Subject: Flying Horse North, SP-17-012, Review 2

This letter responds to your review letter dated May15, 2018 regarding the subject application. Responses to comments are shown in **RED** below the original comment.

OVERALL SITE PLAN AND SHEET KEY

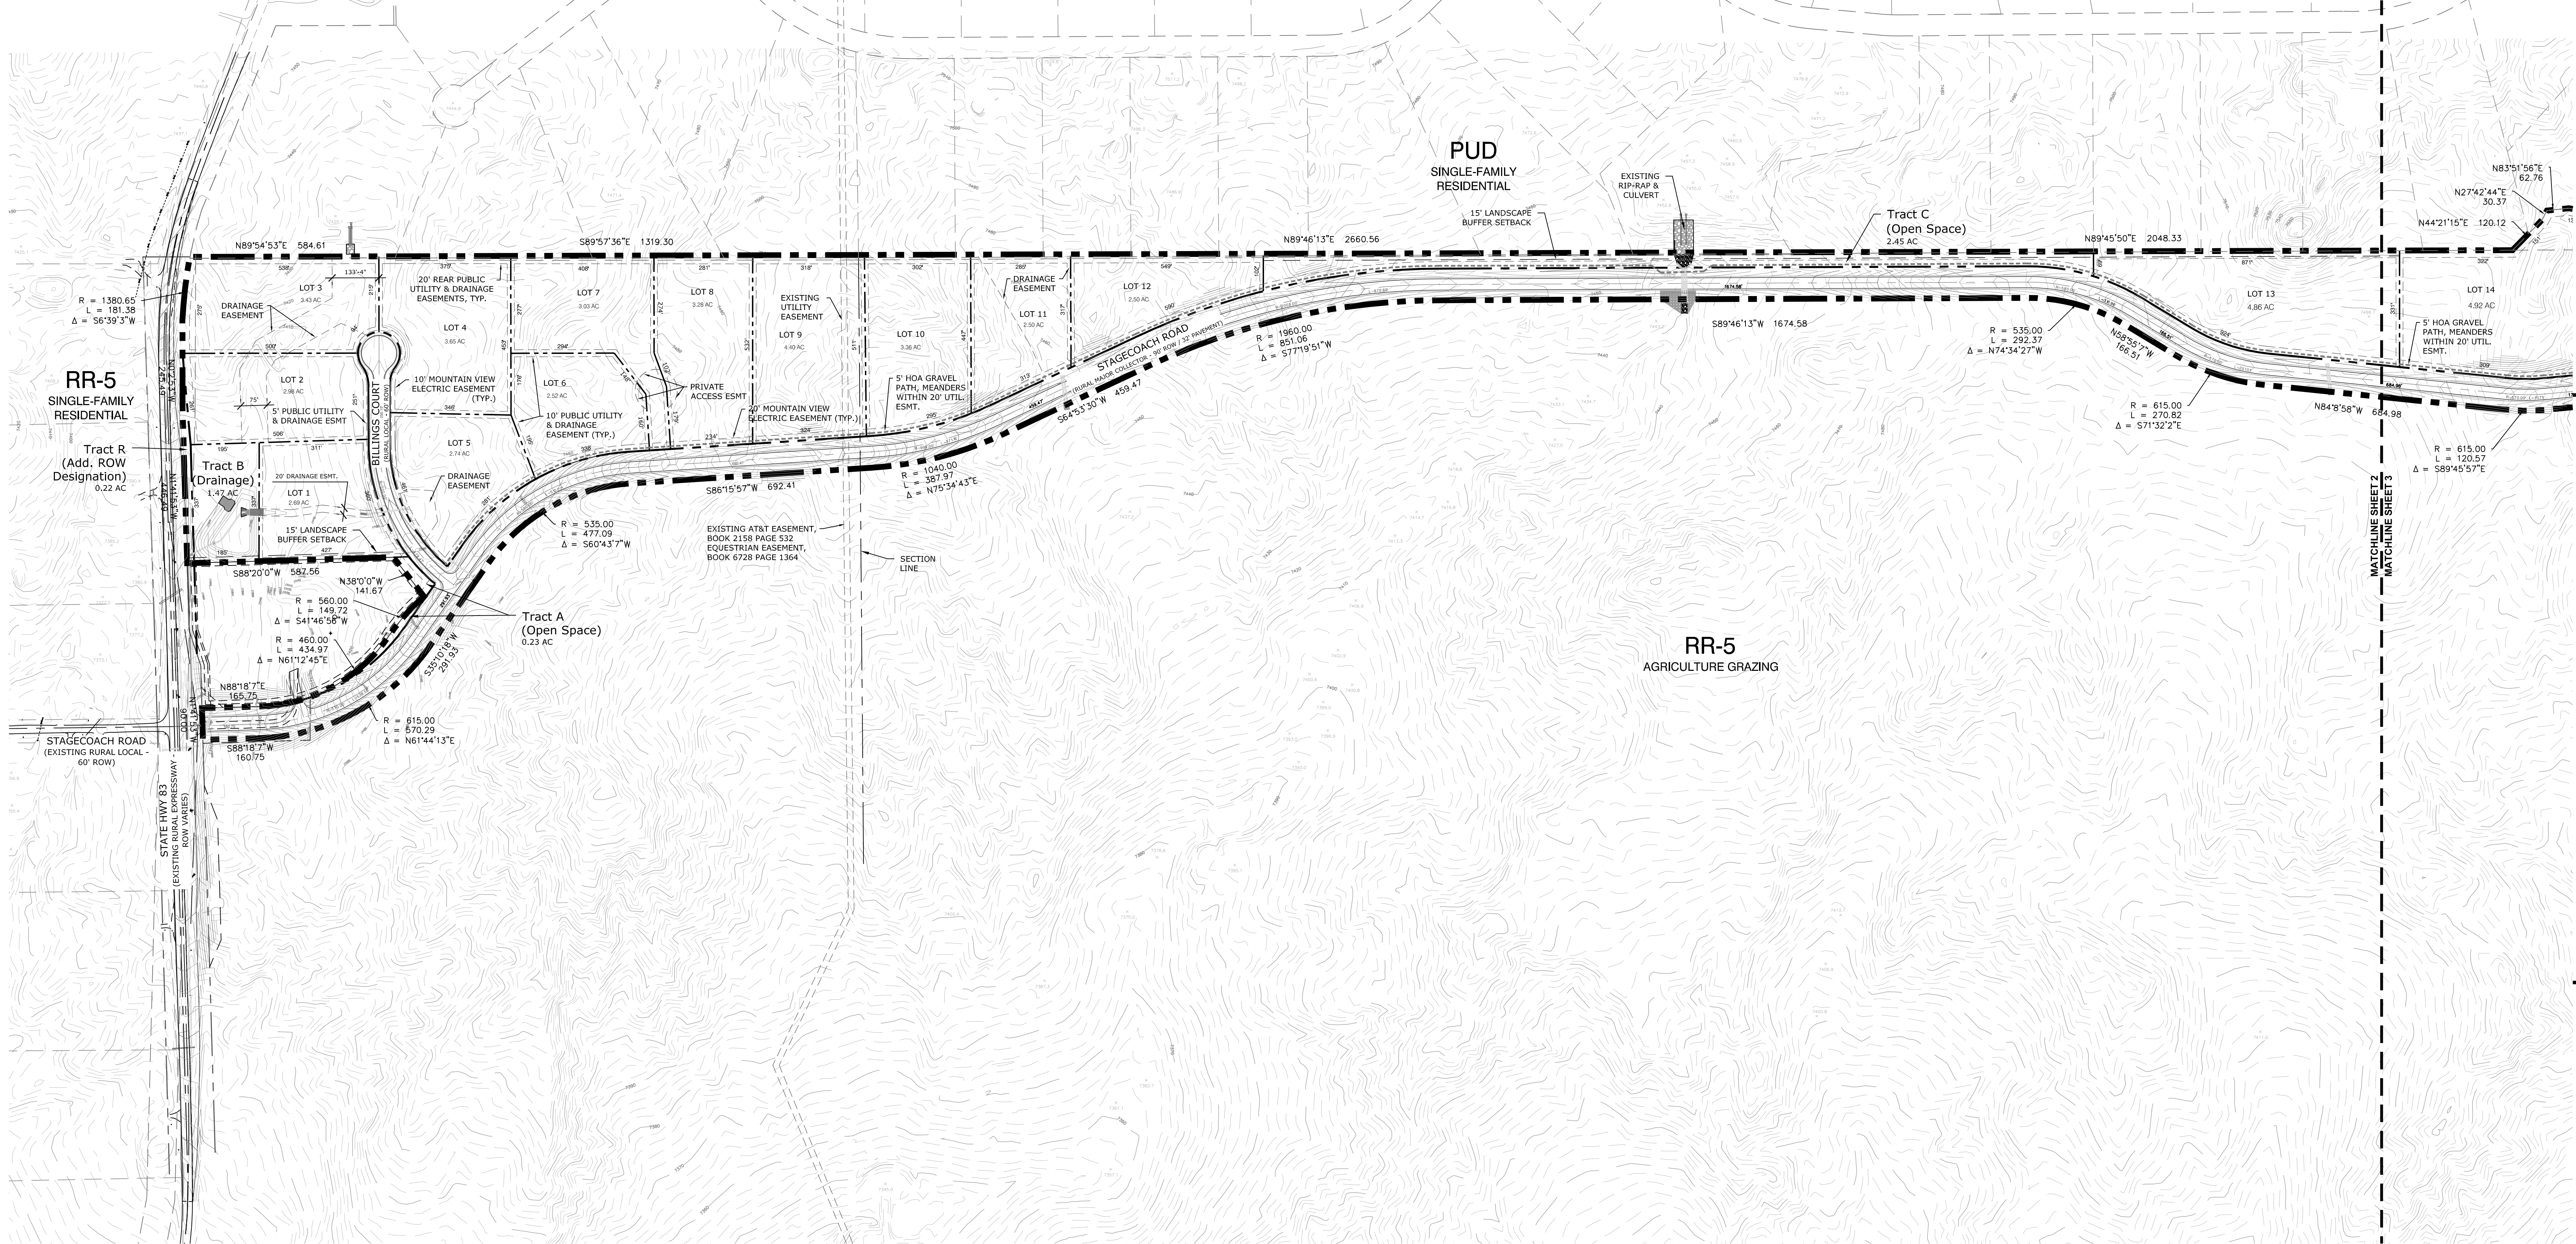
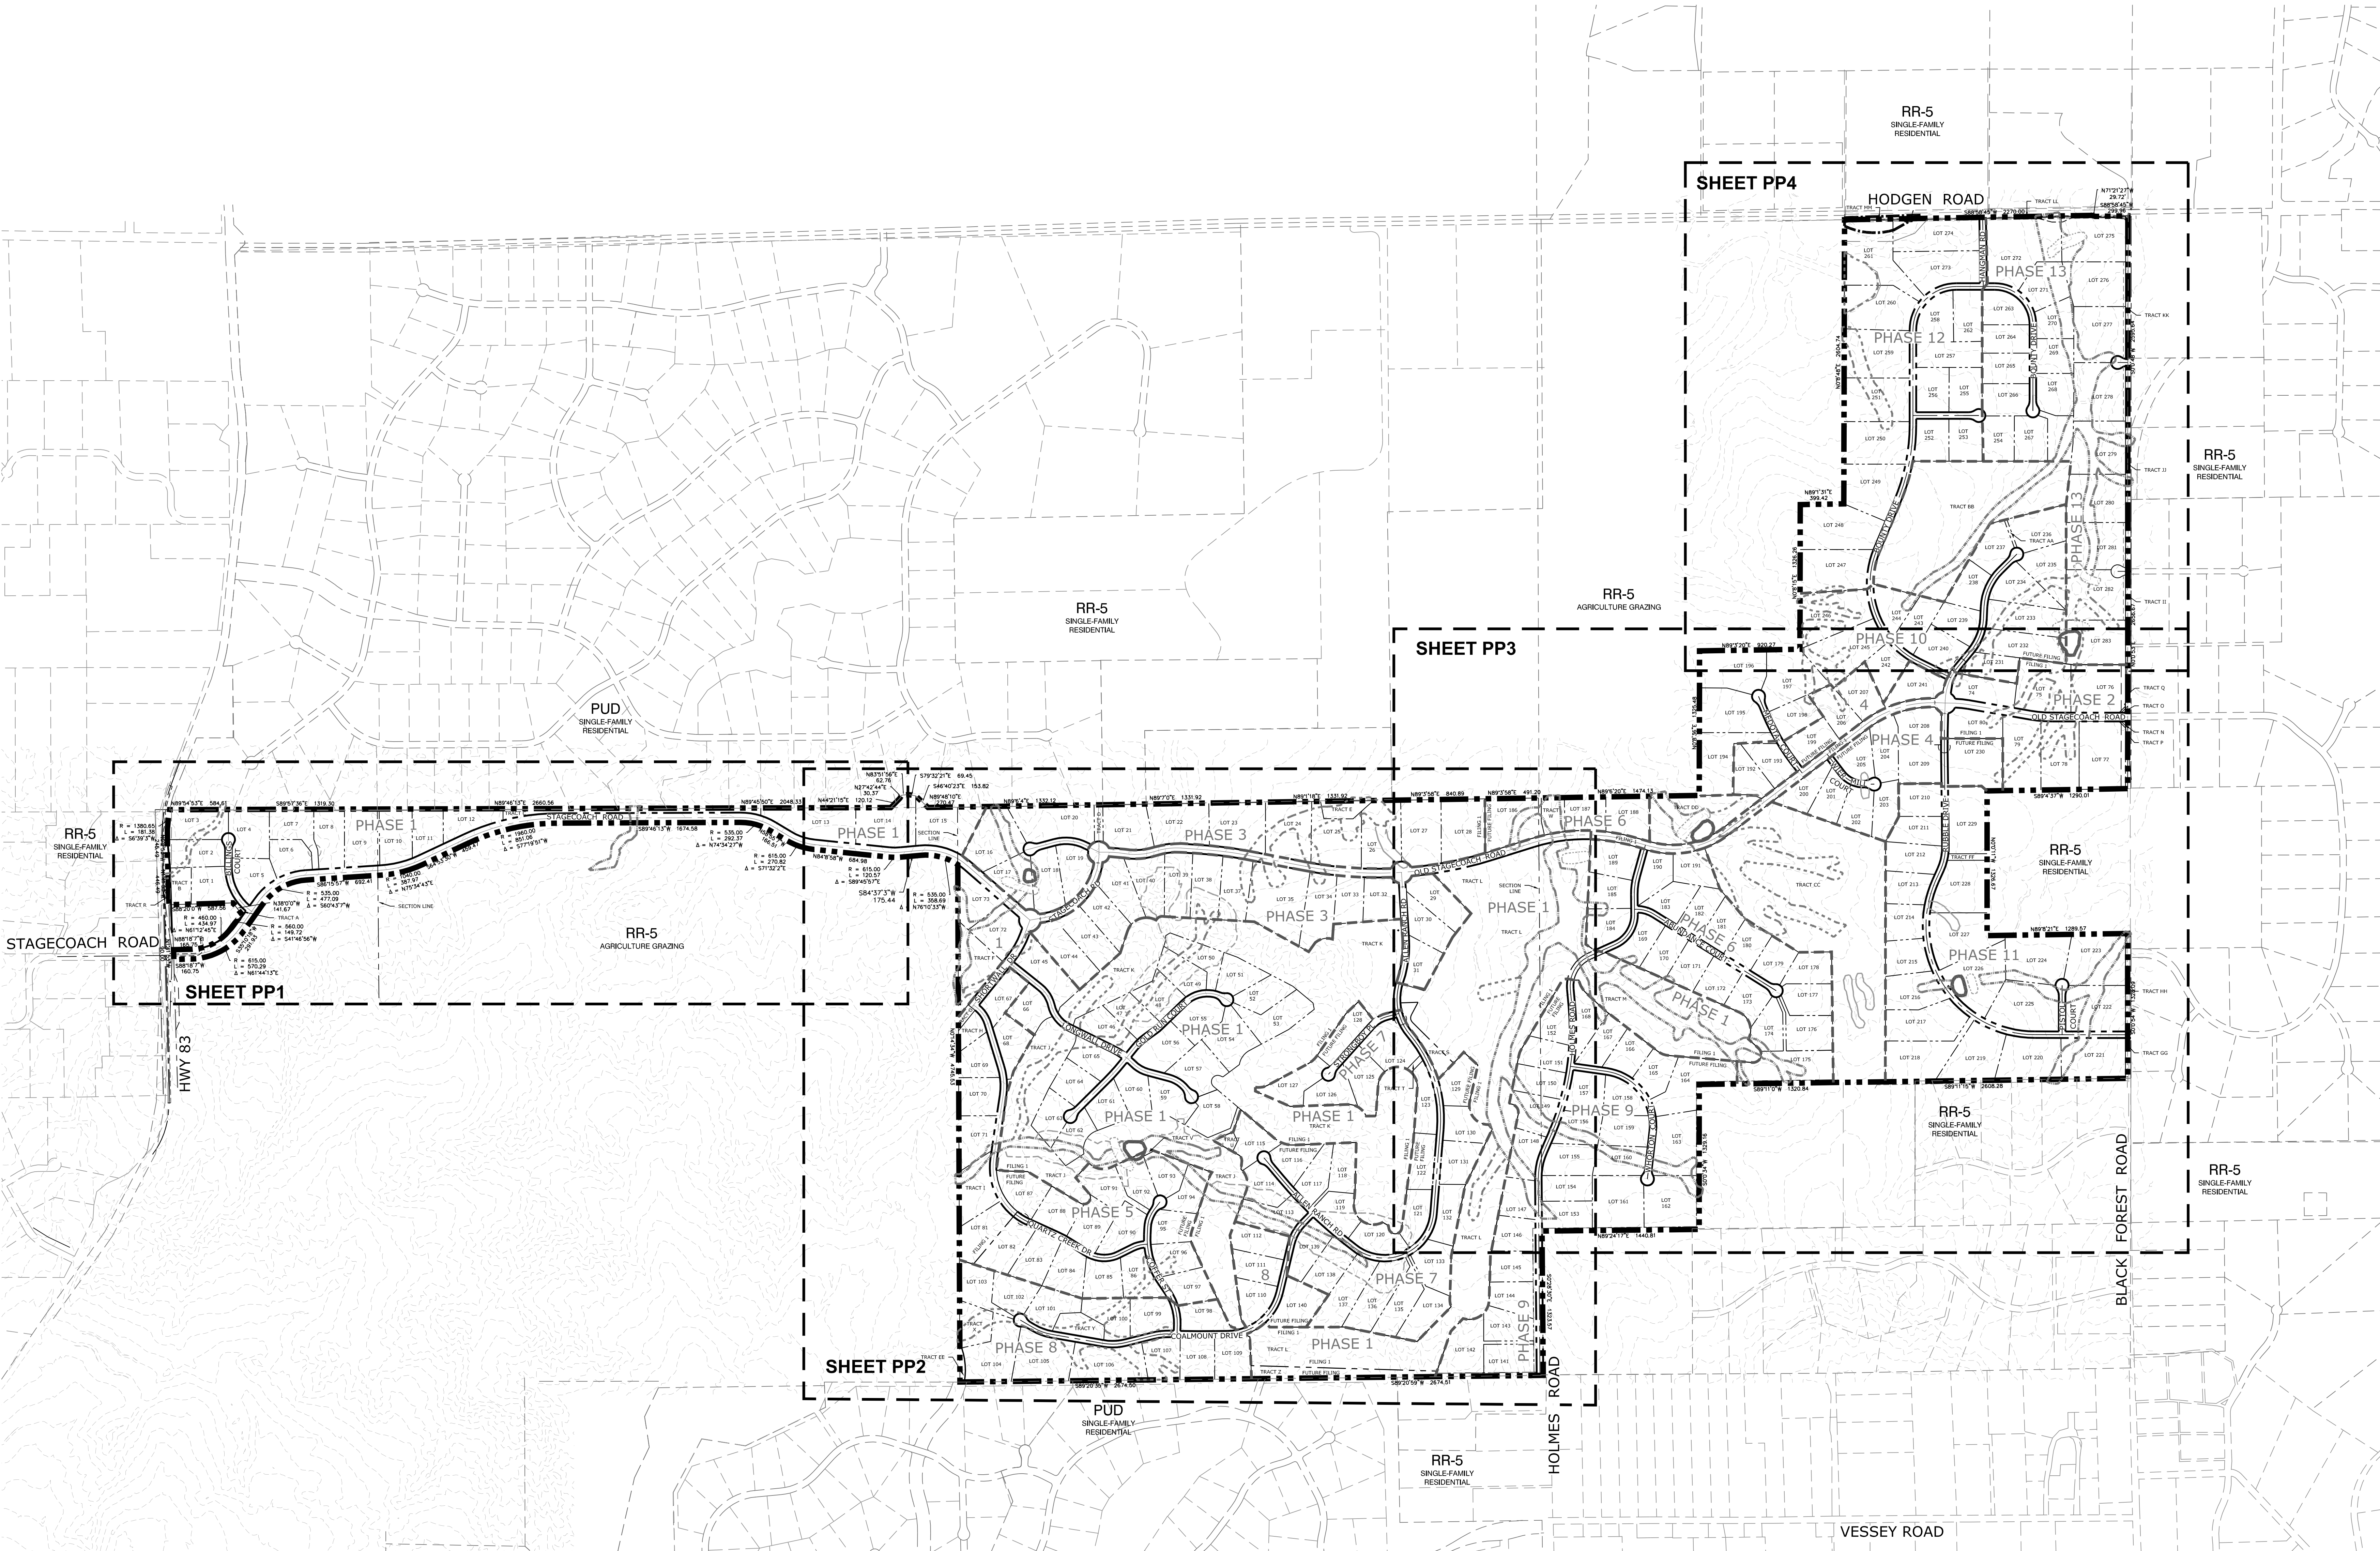
2. As we look at the FH North plan more thoroughly we are concluding that the Holmes Road exit is not needed and could be reserved for an emergency exit.

There is real merit in Holmes being an emergency exit only and not a regular entrance. The current plan has 5 main entrances into FH North (in addition to the two cul-de-sacs) when only 2 are required.

3. We request that a 100-foot setback be established for homes along Black Forest Road and Hodgen Road. This would enhance the development by leaving a buffer back from the road.

Applicant disagrees with this request. Holmes Road access was approved on the recorded PUD Development Plan where this issue was discussed and resolved by BoCC approval.

Applicant disagrees with this request. A combination of additional right-of-way dedication and preservation, along with the topography of this portion of the site, makes this request unfeasible without placing fill in a natural drainage area to create building sites for new homes.
